Designer's Response Condition 3

Project	Lower Farm
Project Number	23995

Comments Received from West Sussex County Council

Date Comments Received 28 November 2025

TITLE Site Layout - Proposed Surface Water
Drainage Sheet 4 Of 4

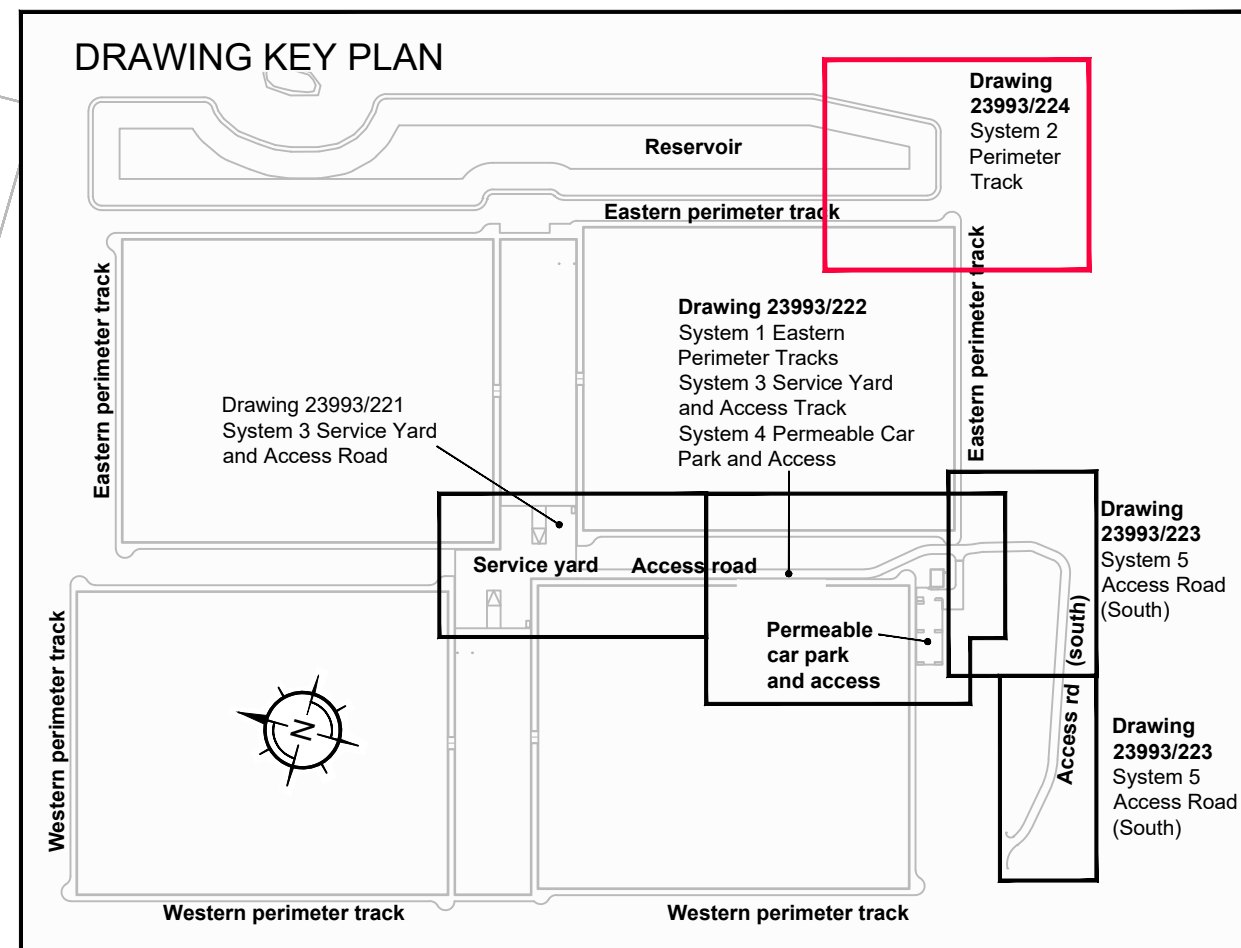
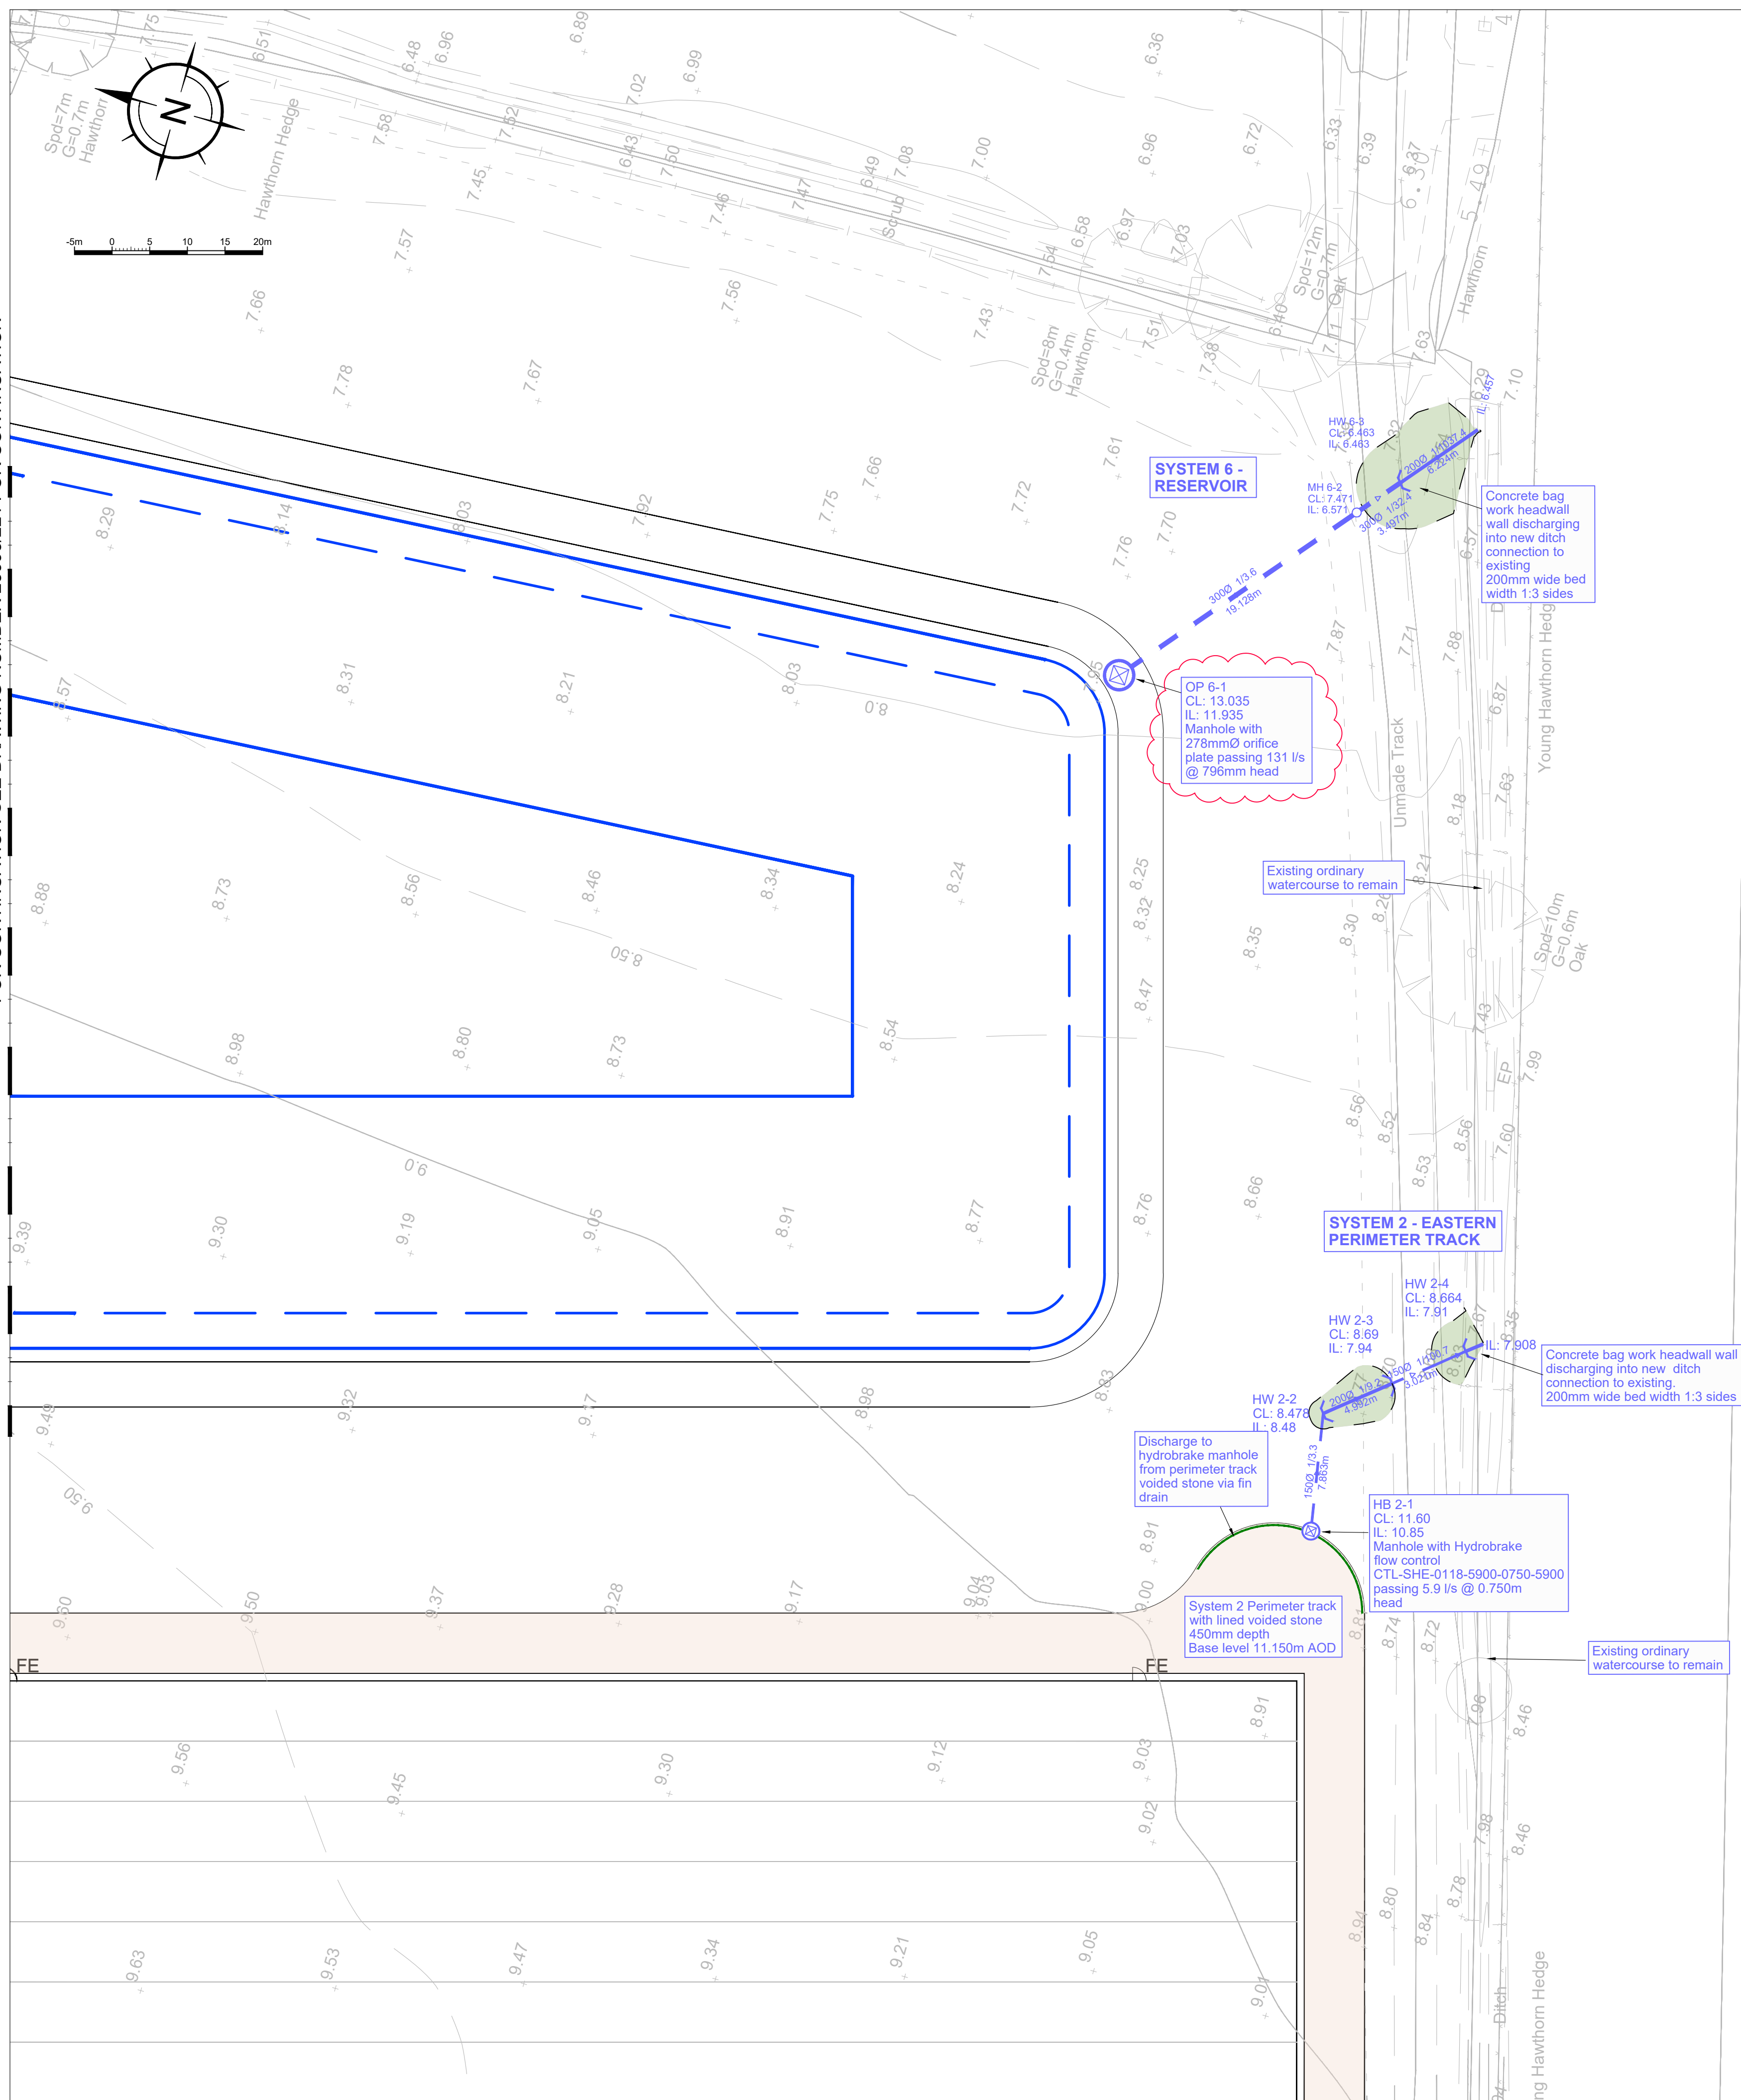
Comment / Query		Designer's response
2	Discharge off-site must not be increased The combined discharge must not exceed QBar, therefore the proposed increased discharges for systems 4 & 5 to manage blockages must either be reduced to QBar or off-set by a reduction to one of the other systems draining to the same watercourse.	Noted, Drainage Statement v1.1, Section 4 has been adjusted to reduce the discharge from Surface Water System 6 from 134l/s to 131 l/s to ensure the total site discharge does not exceed Qbar. Drawings 224, 231, 251 and 526 have been adjusted accordingly to reflect the required minor change to the reservoir design, copies are enclosed in the link in the covering email.
